**Subject:** FW: Consultation on planning application 3/2012/0248 70 St Marys Gardens, Mellor

I have no objection to this proposal, subject to the following conditions:

PROPOSED SITE PLAN

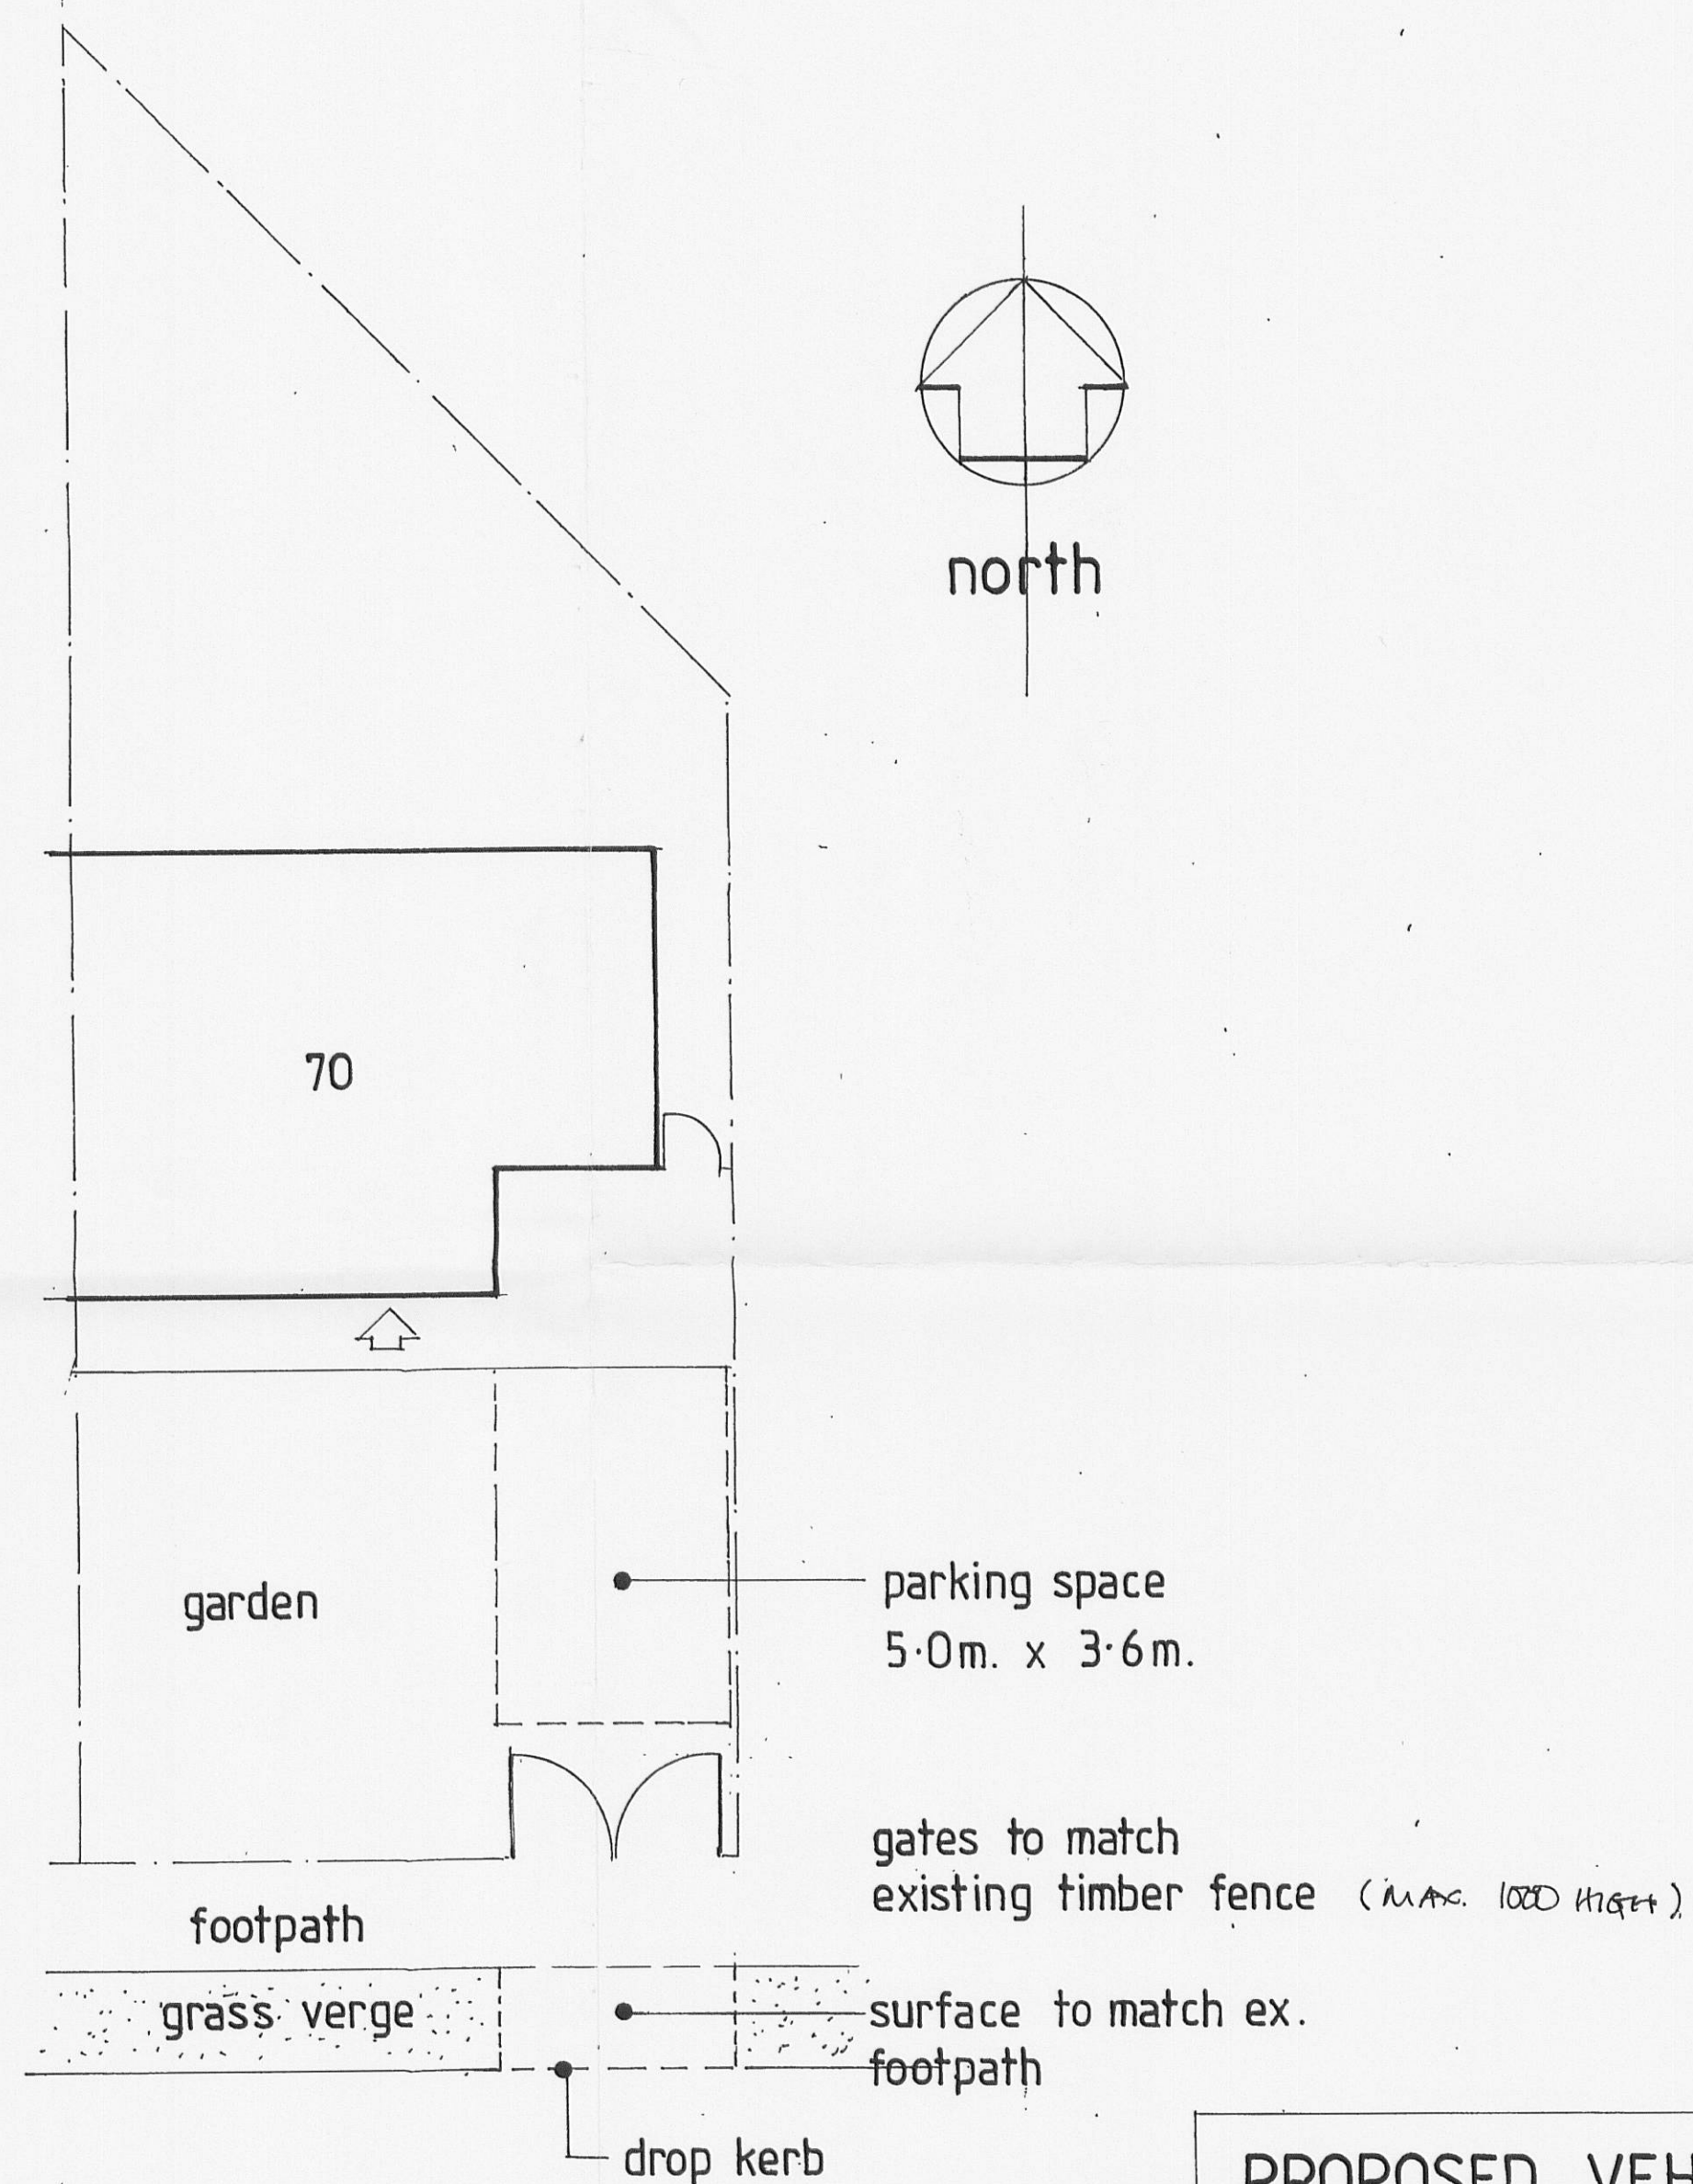
1. Before the access is used for vehicular purposes, any gateposts erected at the access shall be positioned 5 metres behind the nearside edge of the carriageway of St Mary's Gardens. The gates shall open away from the highway. Reason: To permit vehicles to pull clear of the carriageway when entering the site.
2. Before the access is used for vehicular purposes, the driveway detailed on the submitted plans shall be appropriately paved in tarmacadam, concrete, block pavements, or other approved materials. Reason: To prevent loose surface material from being carried onto the public highway thus causing a potential source of danger to other road users.
